Our Case Number: ABP-314942-22

Re: BusConnects Lucan to City Centre Core Bus Corridor Scheme
Lucan to Dublin City Centre

Lucan to City Centre Bus Corridor affecting Palmerstown (Lucan Scheme)

Planning Reasons and Arguments

TYPICAL SECTION P-P
OLD LUCAN ROAD

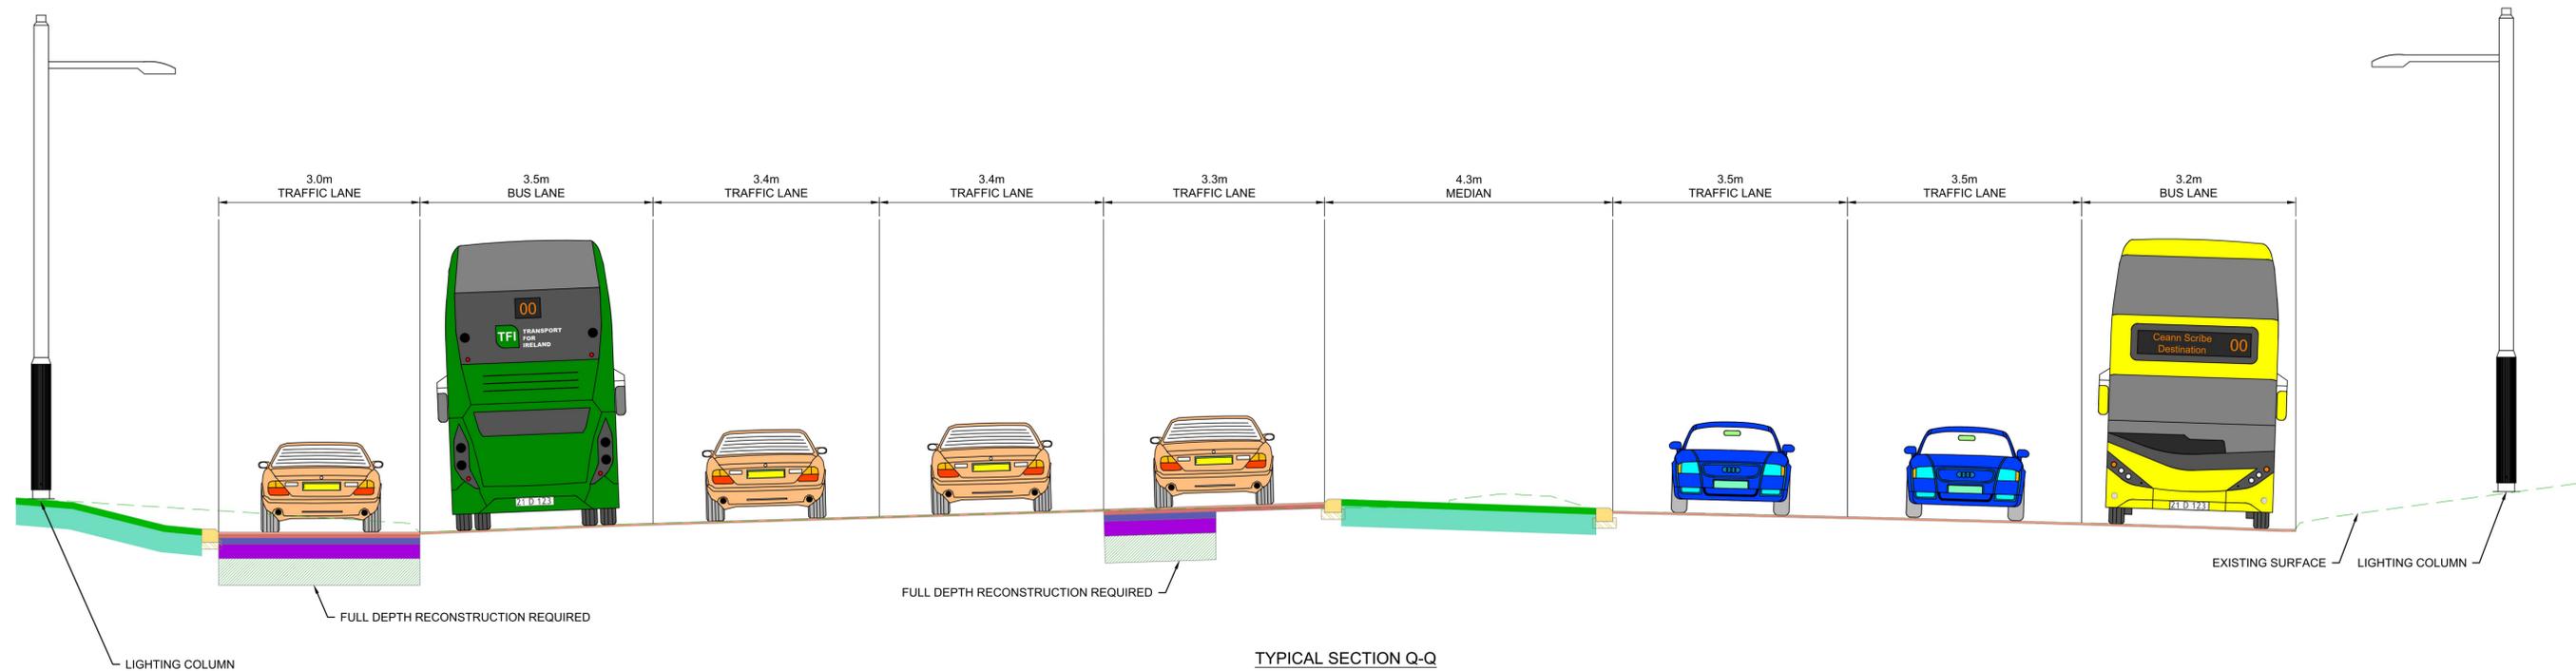
- Two-lane cycleway from M50 wall to behind Applegreen (Church side)
 - Unused cycle lanes as cyclists opt for R148 route out of city centre. Planning does not include measures to reroute cyclists or encourage them to use new route when leaving the city centre.

- Loss of all on-street parking on the north side of the road
- Insufficient access to parking in village. Aldi's private car park is not an option for residents or the council to rely on long term and over use of this will create problems.

- Revised parking at Redcow cottages. No parallel parking replaced by straight in/ out spots.
 - There is not enough space here for straight in/ out spots + pathway + 2 cycle lanes + bus/vehicle traffic lanes.
